KIRKLEES METROPOLITAN COUNCIL INVESTMENT & REGENERATION SERVICE

DELEGATED DECISION TO DETERMINE APPLICATIONS FOR NON-MATERIAL AMENDMENTS

Reference No: **2026/NM/90744/W**

Description: Non material amendment to previous permission 2025/92628 for erection of dwelling and associated works (within a Conservation Area)

Drawing Number 2589 - D - 20 - 010

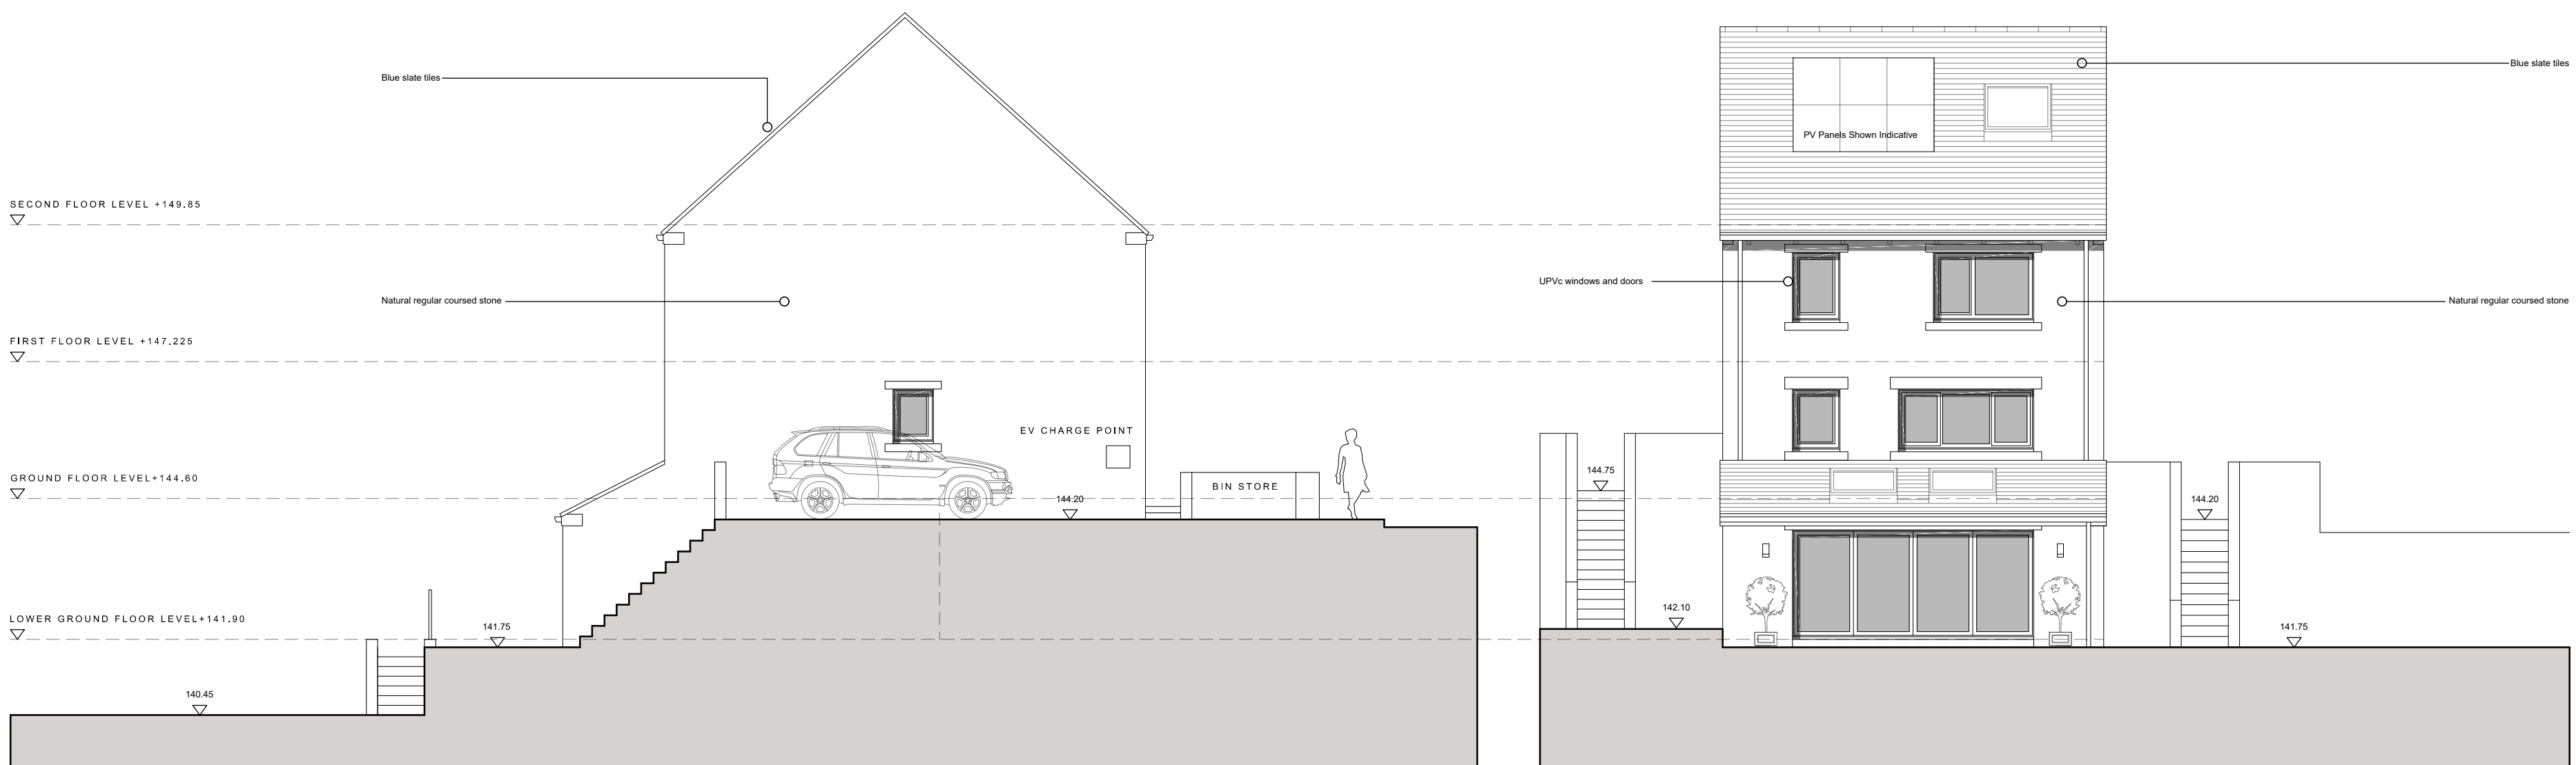
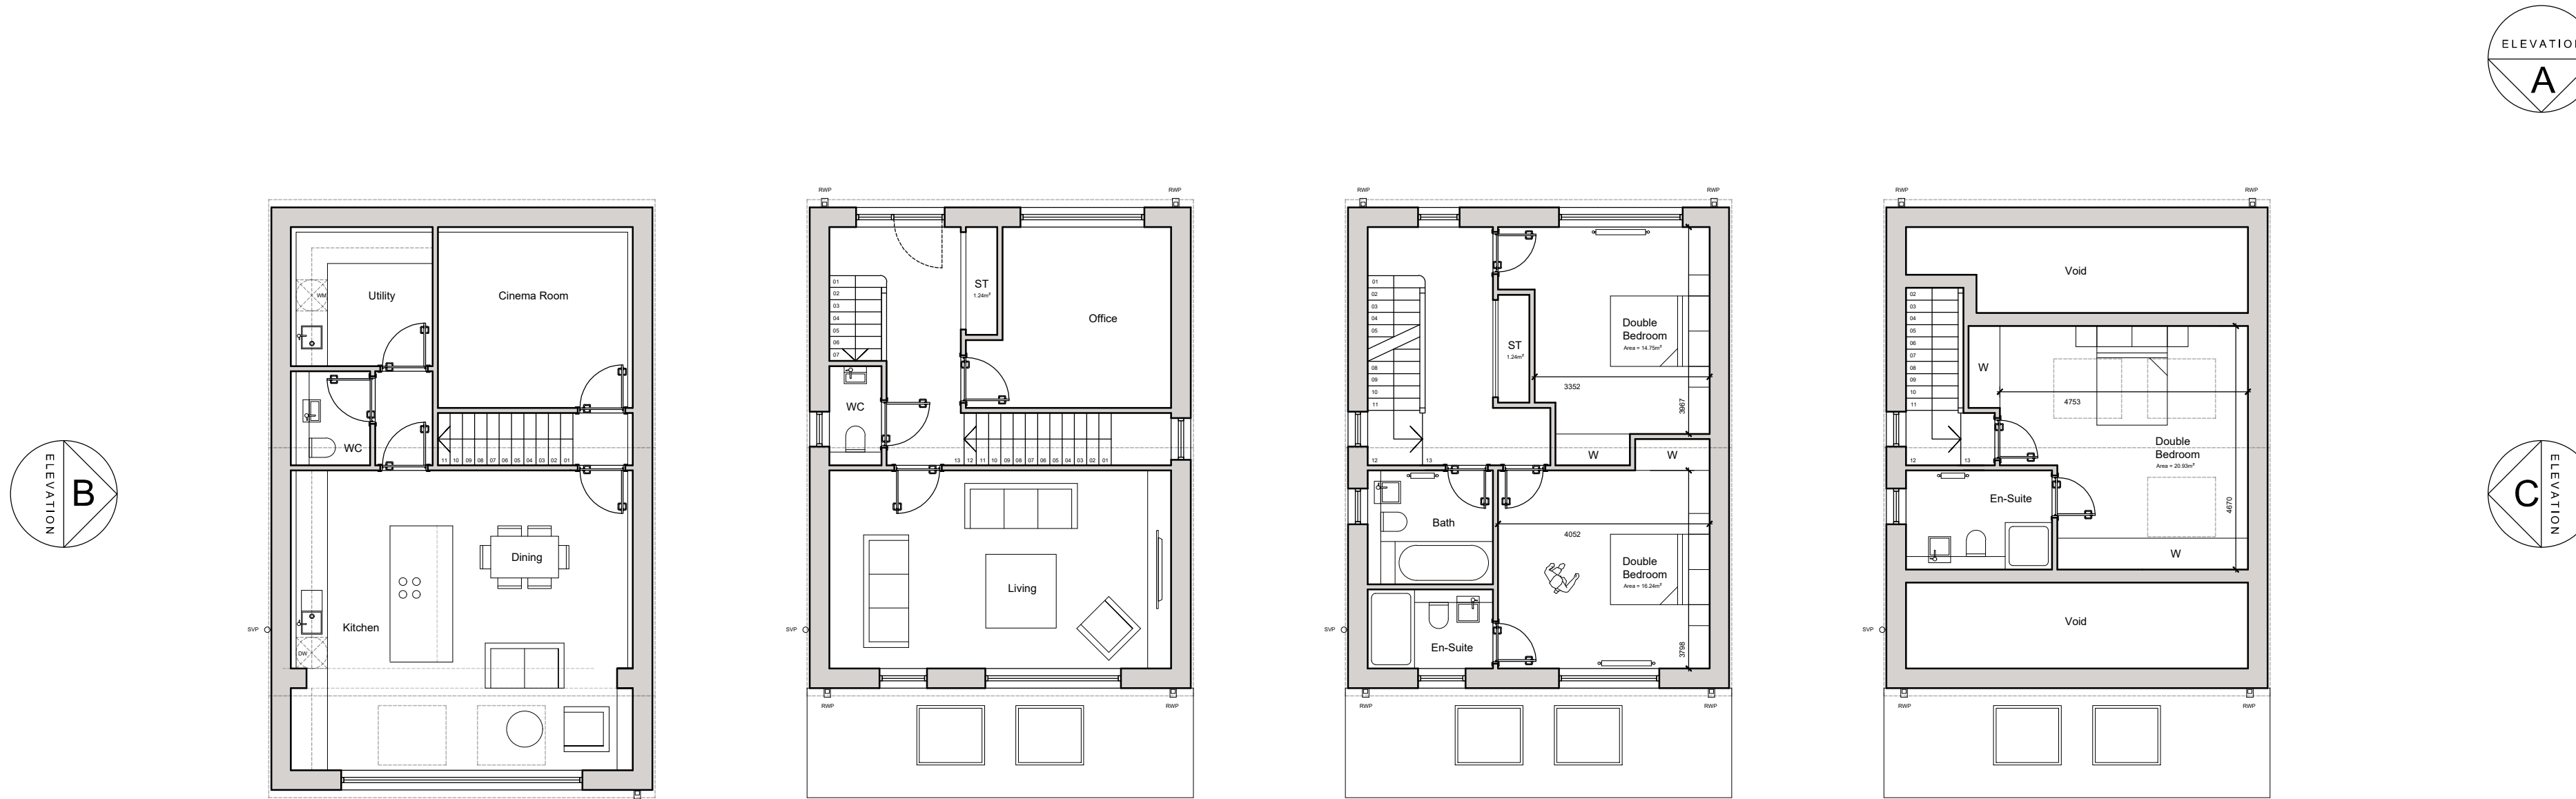
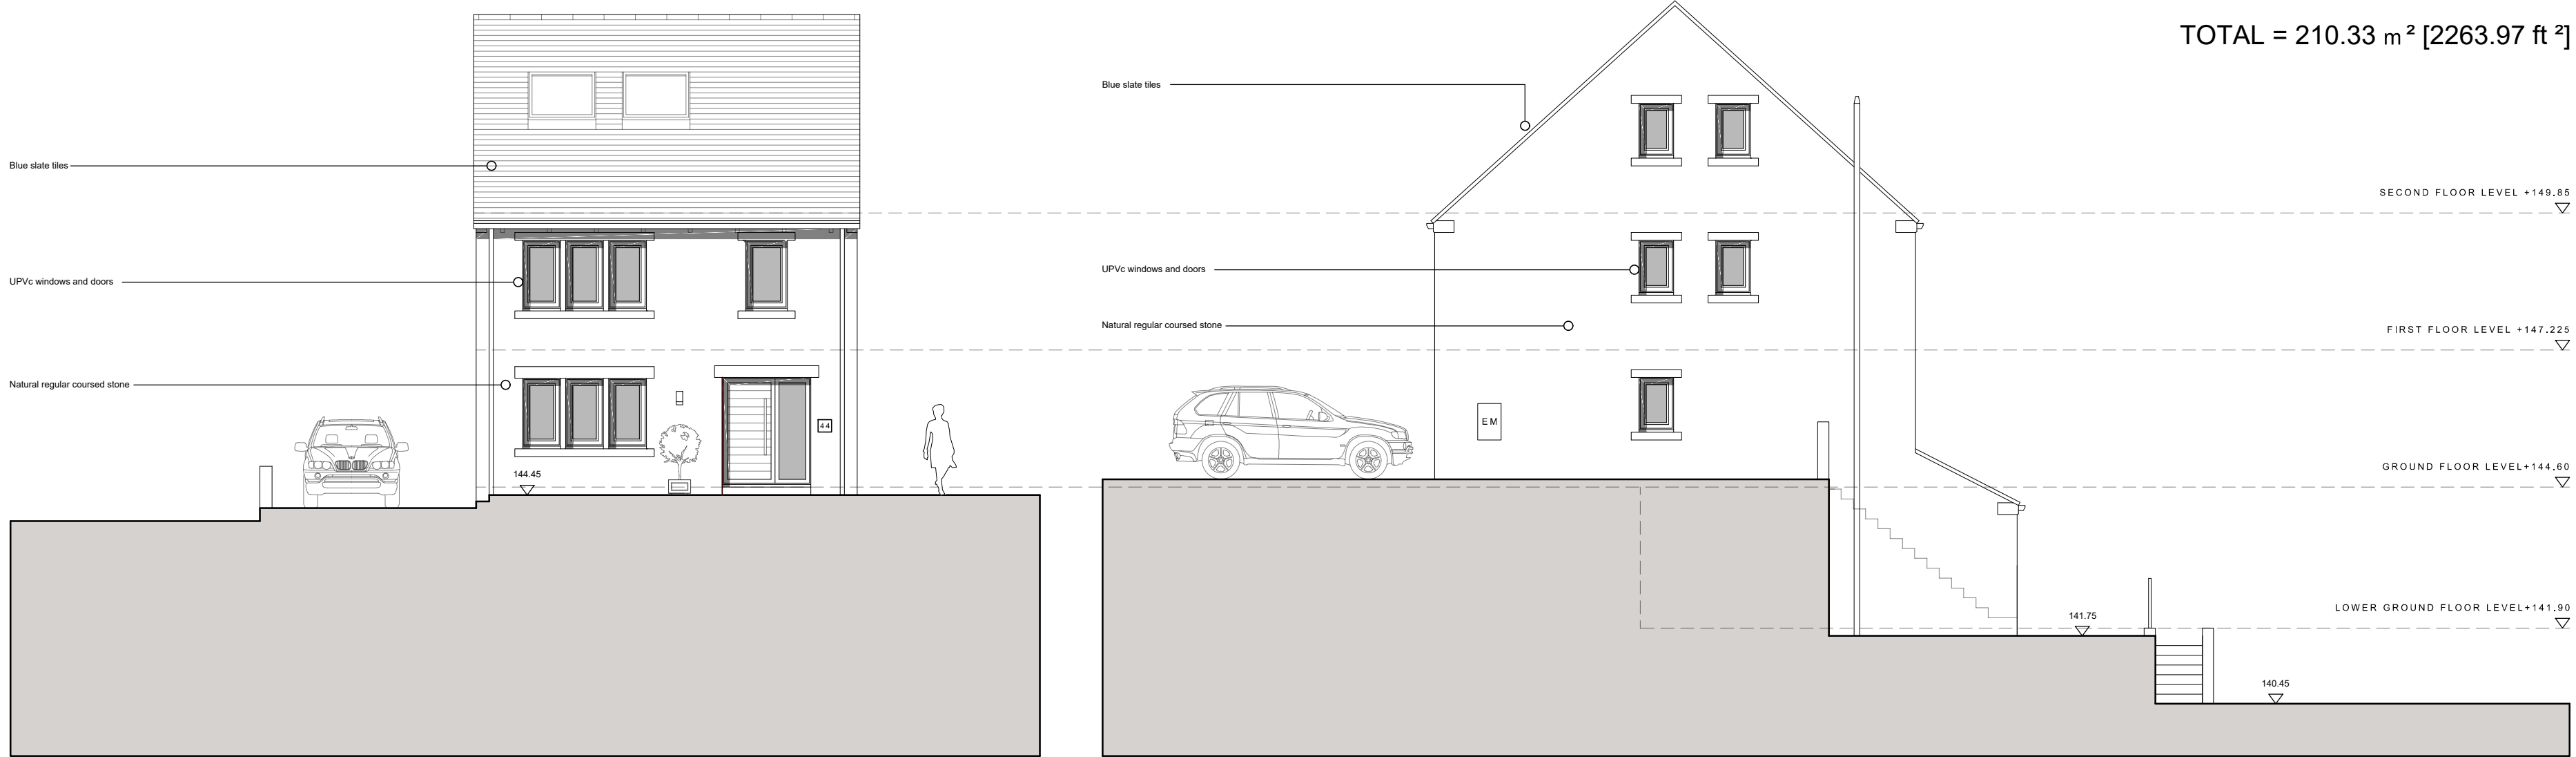
The proposed amendment would see a reduction in the width of the dwelling.

Submitted plan 010revC details the amendments with the front windows being amended from two separate single pane windows, to one three pane window.

The amendments shown on drawing No's. 010revC, 003revC, 005revB & 004revB are considered appropriate to be regarded as a non-material amendment to the previous planning approval 2025/92628
